WEST SUSSEX COUNTY COUNCIL CONSULTATION

TO:	Arun District Council FAO: Neil Crowther
FROM:	Highways, WSCC
DATE:	30/04/2021
LOCATION:	Land Adjacent Mistletoe Farm, Horsemere Green Lane, Climping, BN17 5QZ
SUBJECT:	CM/18/21/PL Erection of 1 No. 3 bed dwelling. This application is within CIL Zone 3 and is CIL liable as new dwelling.
DATE OF SITE VISIT:	N/A
RECOMMENDATION:	Advice
S106 CONTRIBUTION TOTAL:	£N/A

sheet 1 of 3

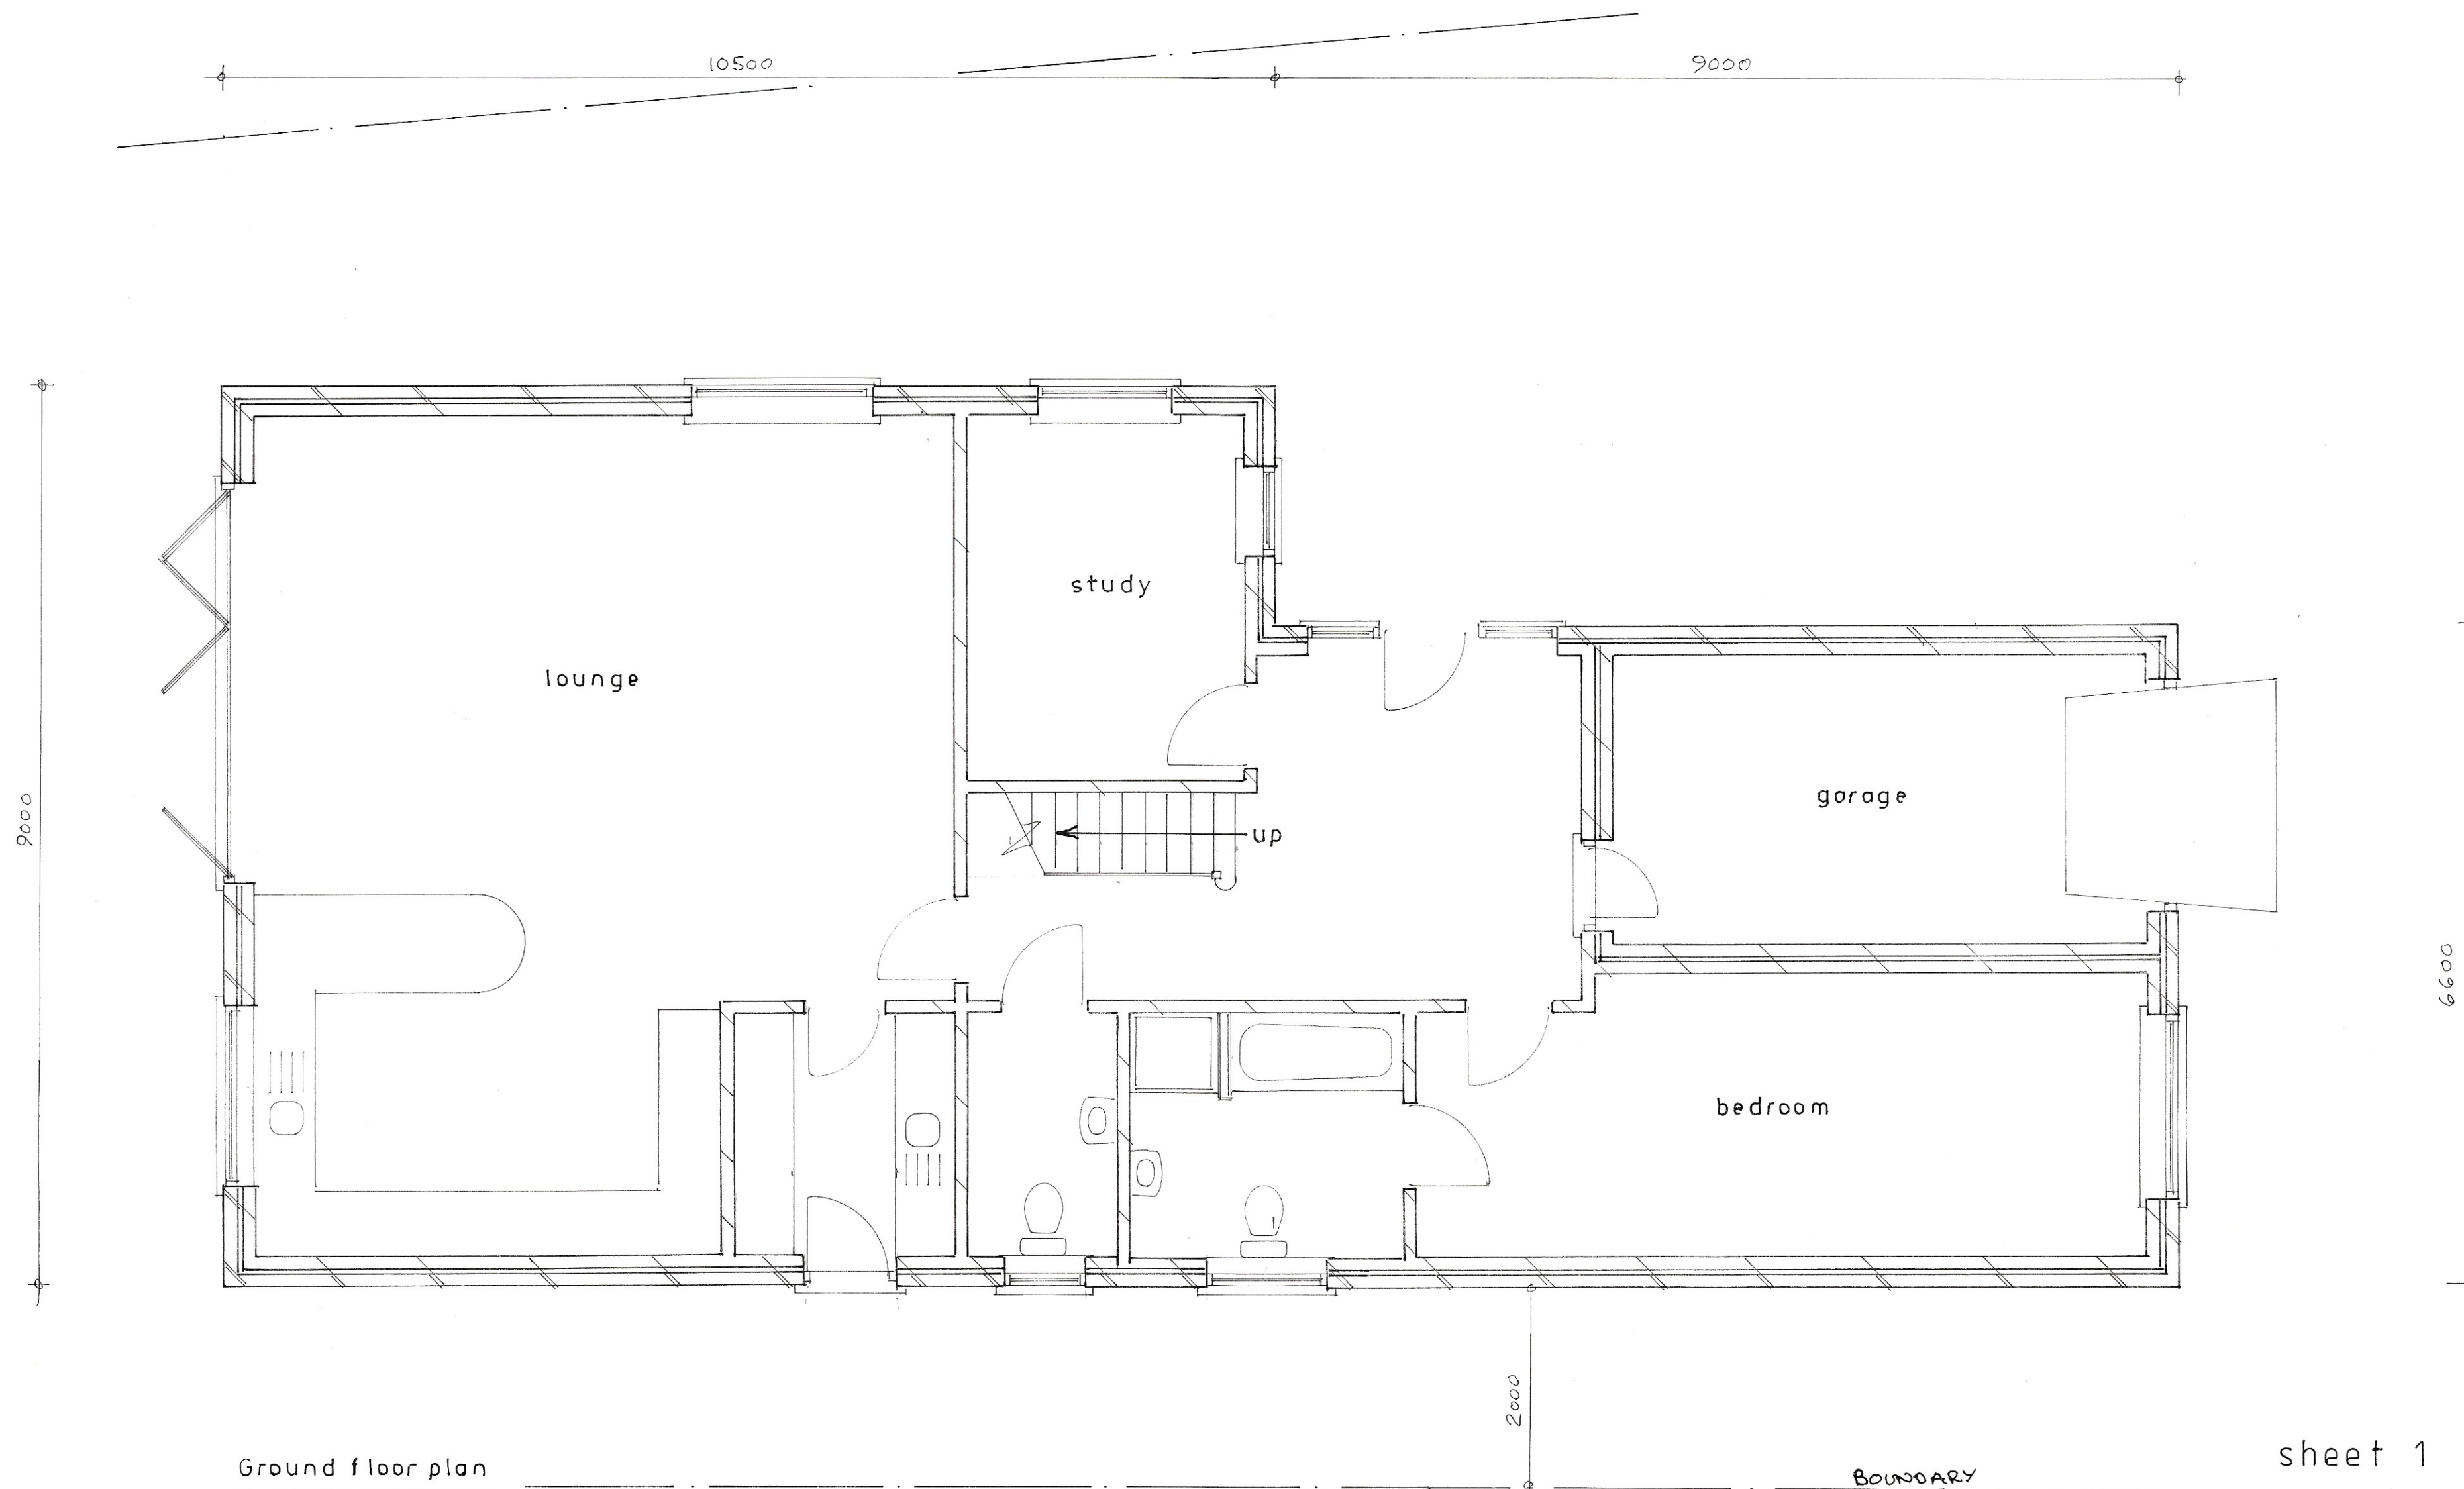
The applicant proposes a single-car garage and driveway for vehicular parking provision. Under Arun Parking Standards (adopted January 2020), the LHA would anticipate that two parking spaces would be sufficient for a dwelling of this size and location. Therefore, the LHA considers the proposed parking provision to be sufficient. On-site turning appears achievable, allowing cars to exit the site in a forward gear.

The LHA notes that the proposed garage has approximate internal dimensions of 2.9m x 5.3m, which does not meet the minimum internal dimensions for single-car garages of 3m x 6m as set out in Manual for Streets (MfS). Therefore, the LHA cannot consider the garage for vehicular or cycle

parking provision and advises the applicant to enlarge the garage to meet MfS specifications. Notwithstanding this, the LHA is satisfied that sufficient parking will be available on site for the use.

Regarding cycles, the applicant has not demonstrated cycle parking provision. The LHA advises the applicant to demonstrate secure and covered cycle parking, in accordance with Arun Parking standards. The inclusion of cycle parking helps promote the use of sustainable transport methods.

No part of the development shall be first occupied until the car parking has been constructed in accordance with the approved site plan. These spaces shall thereafter be retained at all times for their designated purpose.

No part of the development shall be first occupied until covered and secure cycle parking spaces have been provided in accordance with plans and details to be submitted to and approved by the Local Planning Authority.
